**Re: Veterans Integration Center at 2701 Mulberry St SE.
Erosion and Sediment Control Plan
Engineer's Stamp Date 4/27/23 (M15E054)**

Based upon the information provided in your submittal received 5/3/23, the above-referenced ESC Plan is conditionally approved to be in the SWPPP for the purposes of Grading Permit., however it is not approved for Building Permit until the following additional information is provided.

ESC-1

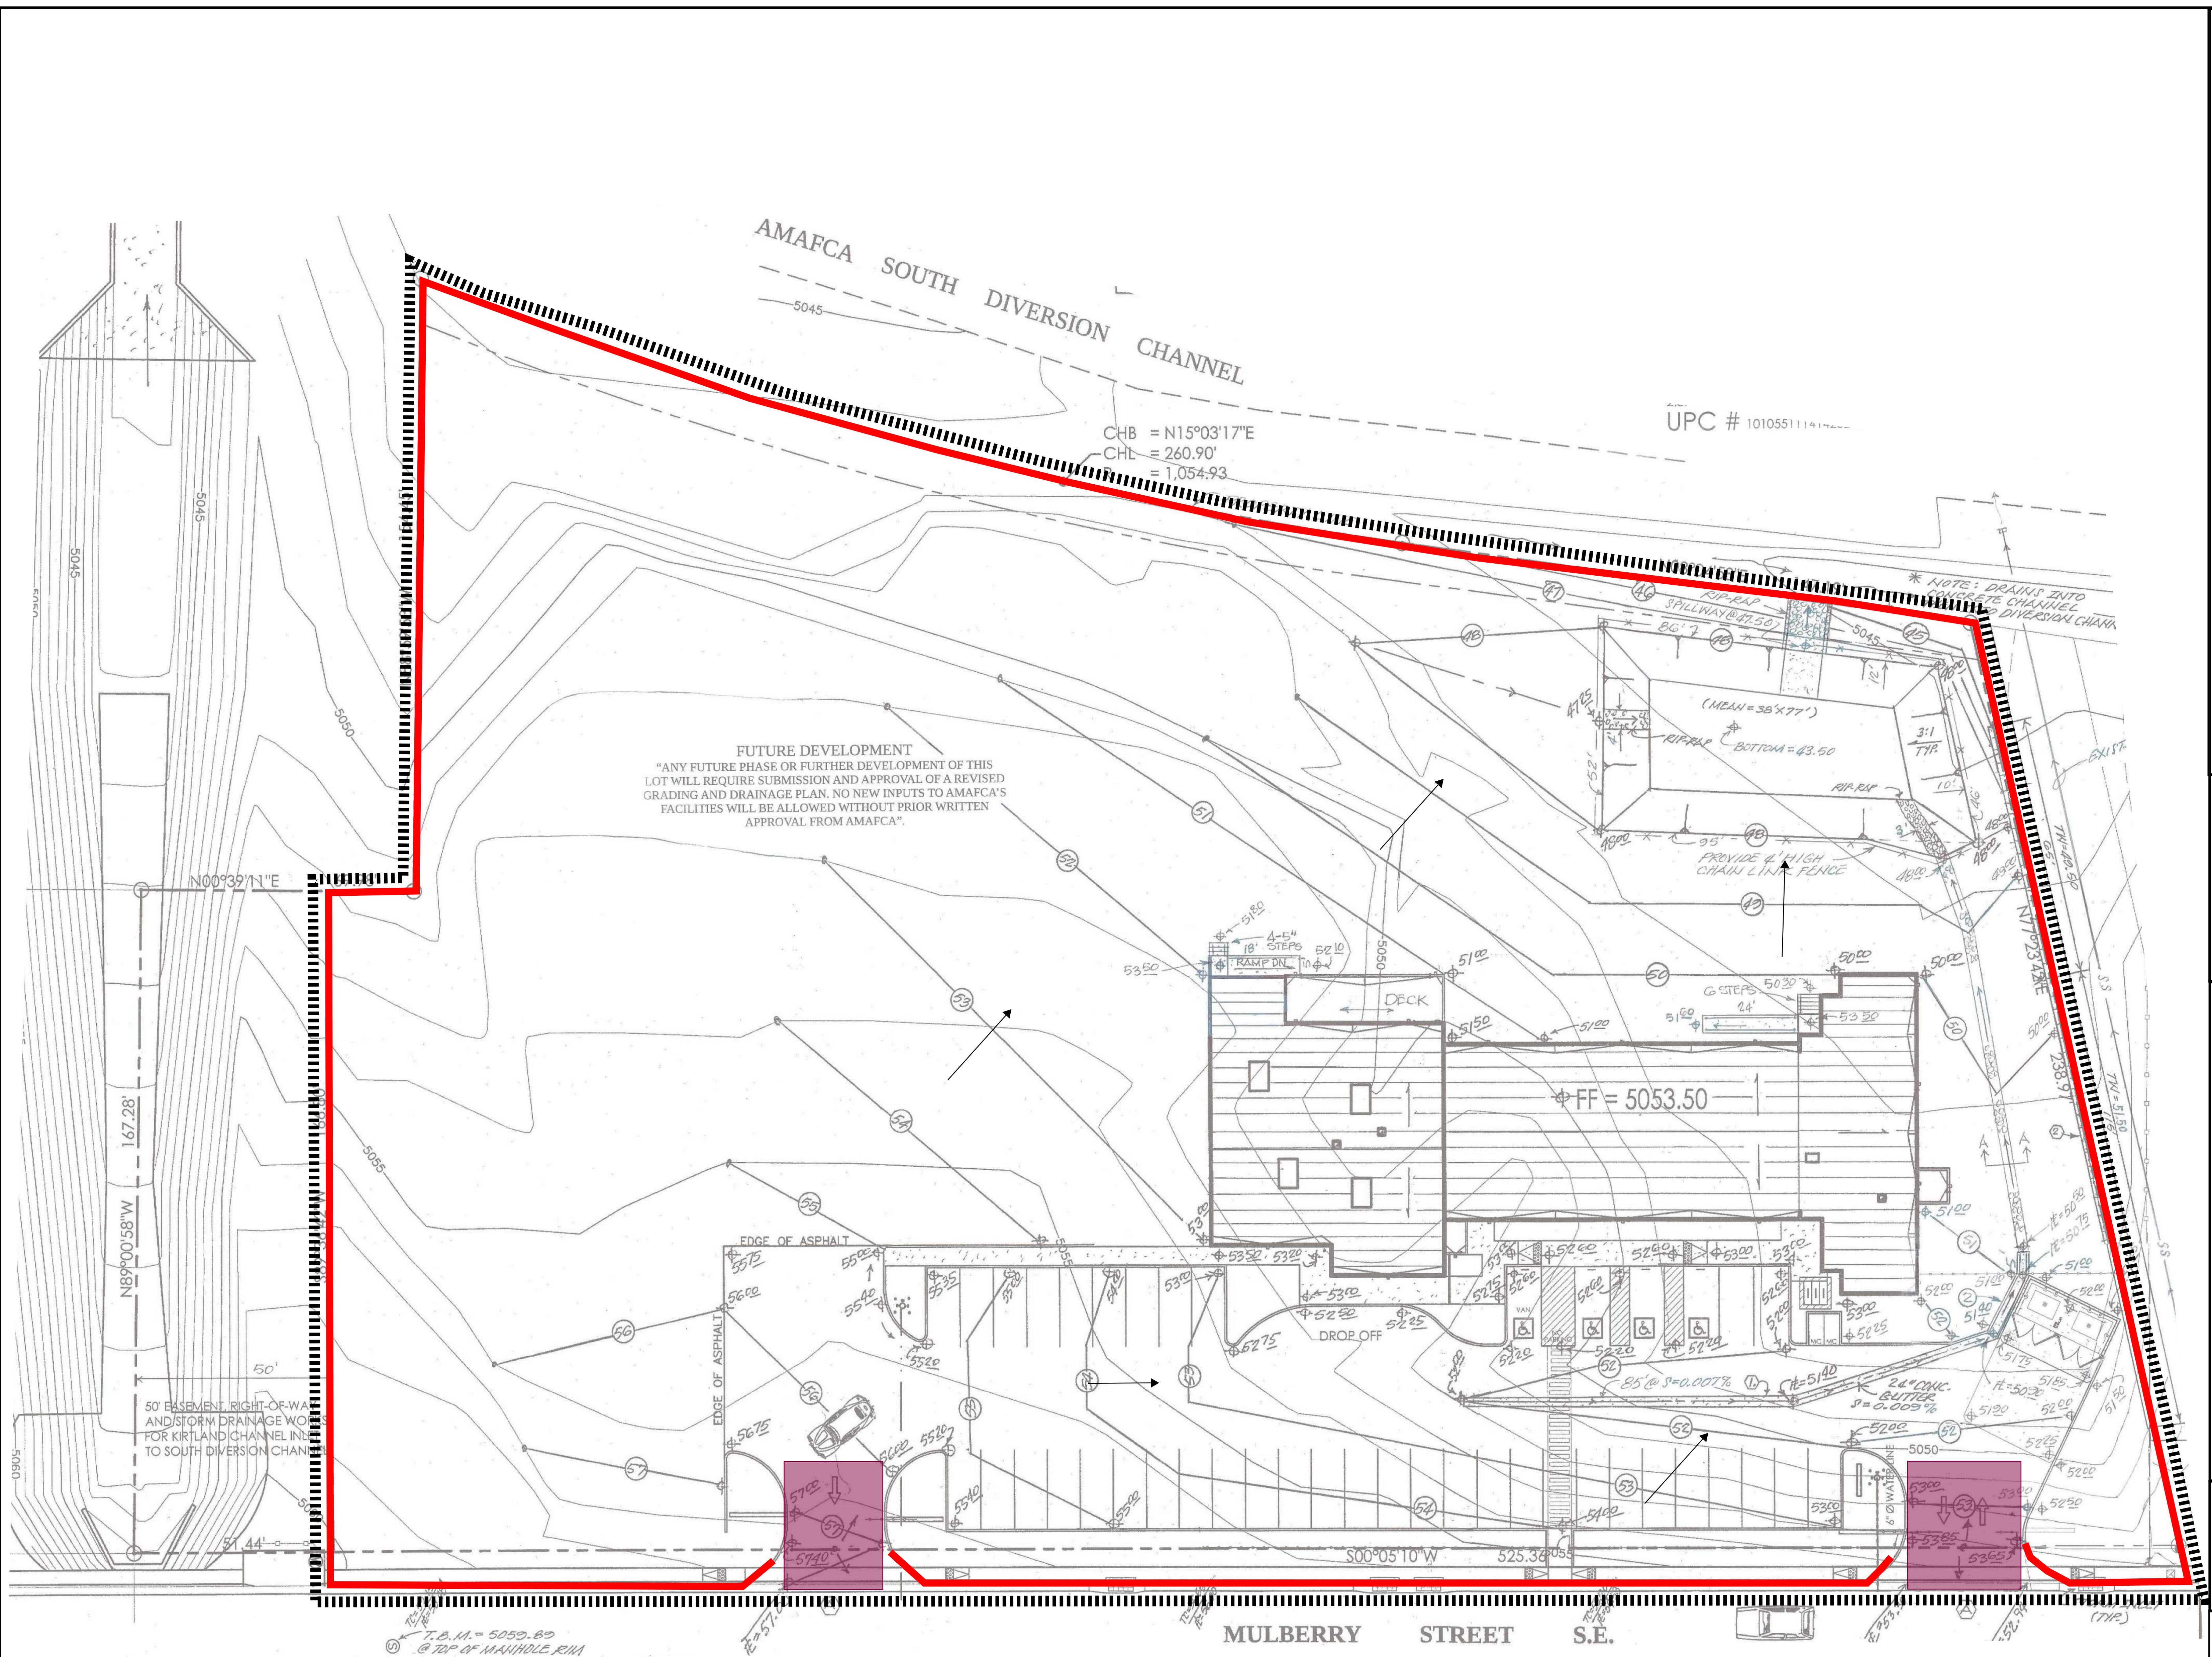
1. The SWPPP must include site-specific interim and permanent stabilization per CGP 9.6.1.c.i. Provide a specifications on the ESC Plan along with schedules for implementation per CGP 2.2.14. Label areas where existing vegetation is to be preserved and not graded at this time, if any. Label areas to be stabilized with landscape rock (all areas in the public ROW) and show typical section and specifications. Label areas to be stabilized with vegetation and provide details and specifications.

2. I can't tell the difference between building, sidewalk, asphalt, and landscaping on the ESC Plan. These structures must be clearly identified in the SWPPP per CGP 7.2.4.b.vi. The same information is required in the ESC Application. You may attach a copy of the Site Plan to both the SWPPP and the ESC Application to address this requirement, but discrepancies between the plans should be resolved so that the ESC Plan agrees with the Site Plan.
